January 3, 2013

**RE: Response to City Review Comments
Level I Site Plan Development Review Application
Motley Street Extension, Portland, Maine**

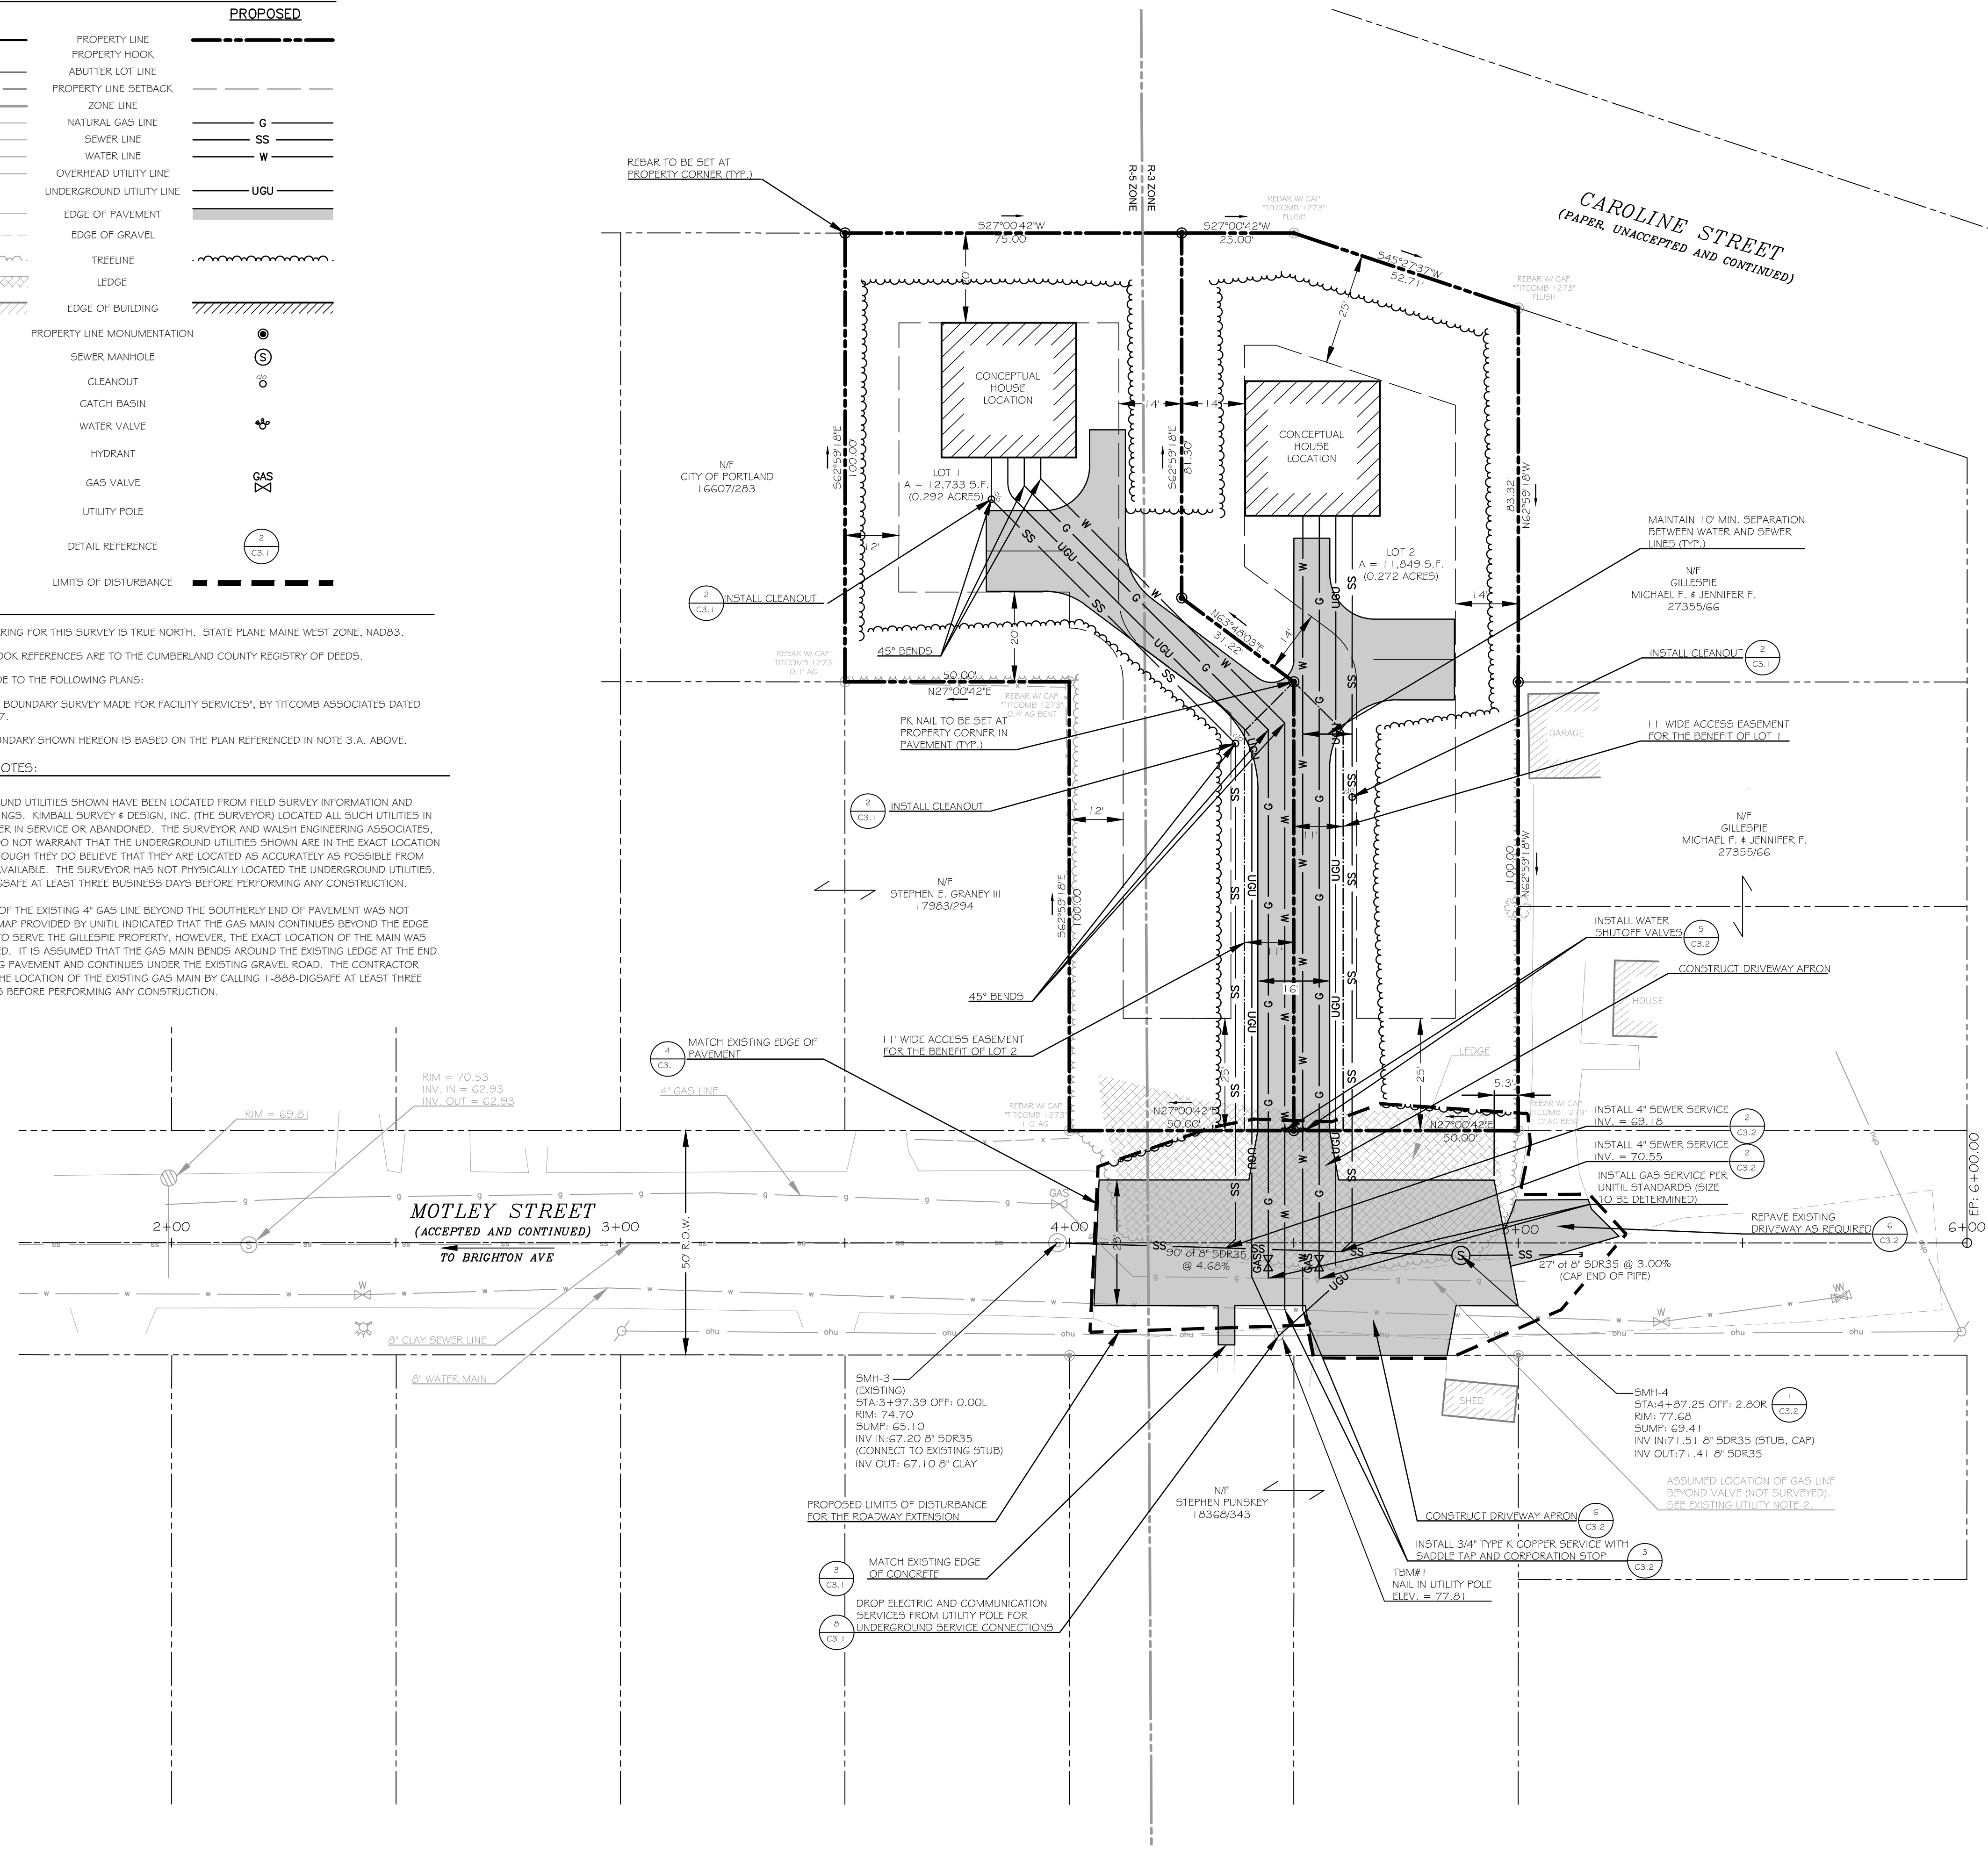
The project data sheet has been revised to indicate the existing and proposed impervious area associated with the roadway construction area only. The existing impervious area within the roadway construction area is 4,323 square feet, which includes existing gravel, pavement, and exposed ledge. The total paved area is 3,390 square feet. As all of the proposed paved area will be constructed over existing impervious area, there will be no net increase in impervious area as a result of the development.

Walsh Engineering Associates, Inc. has reviewed section 3.7 of the City's Technical Manual and has added a note to sheets C.2.0, C2.1, and C3.0 that a blasting permit and all associated submittals will be required for a "large blast" operation (removal of greater than 300 c.y. of rock material).

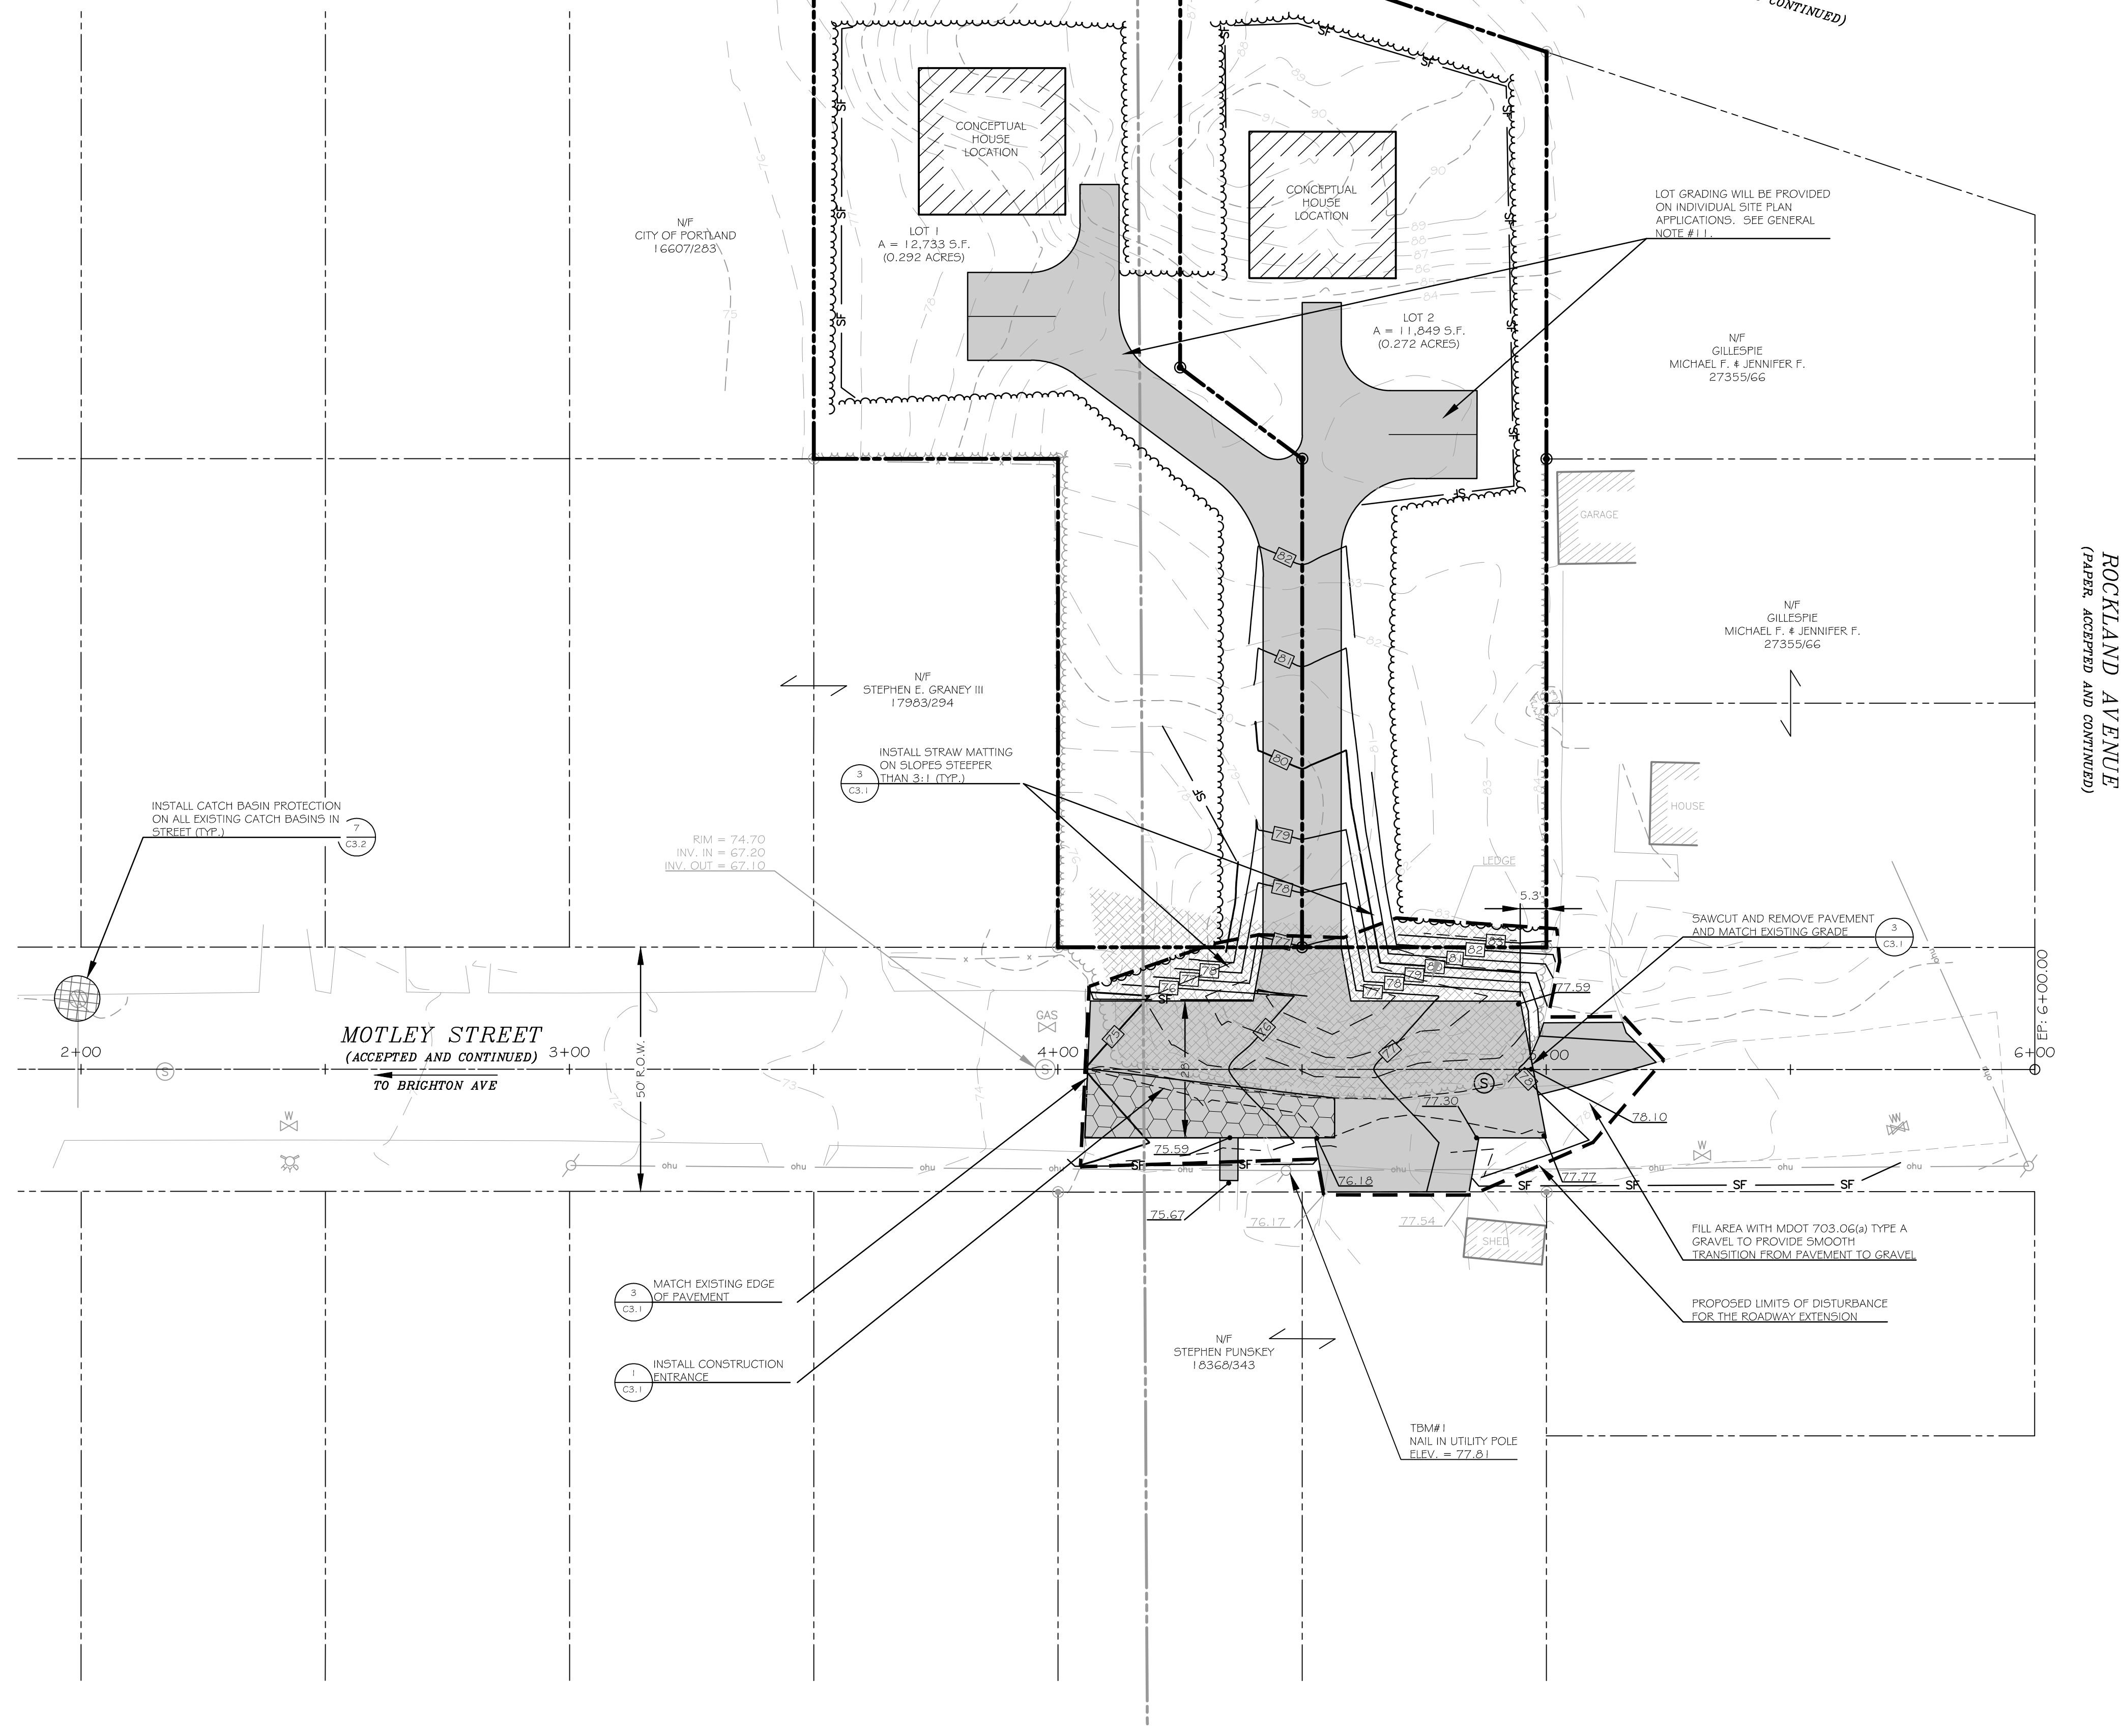
Catch basin inlet protection provisions have been added to the site plans. A symbol and leader note have been added to sheet C2.1 and the appropriate detail has been added to sheet C3.2 (detail #7).
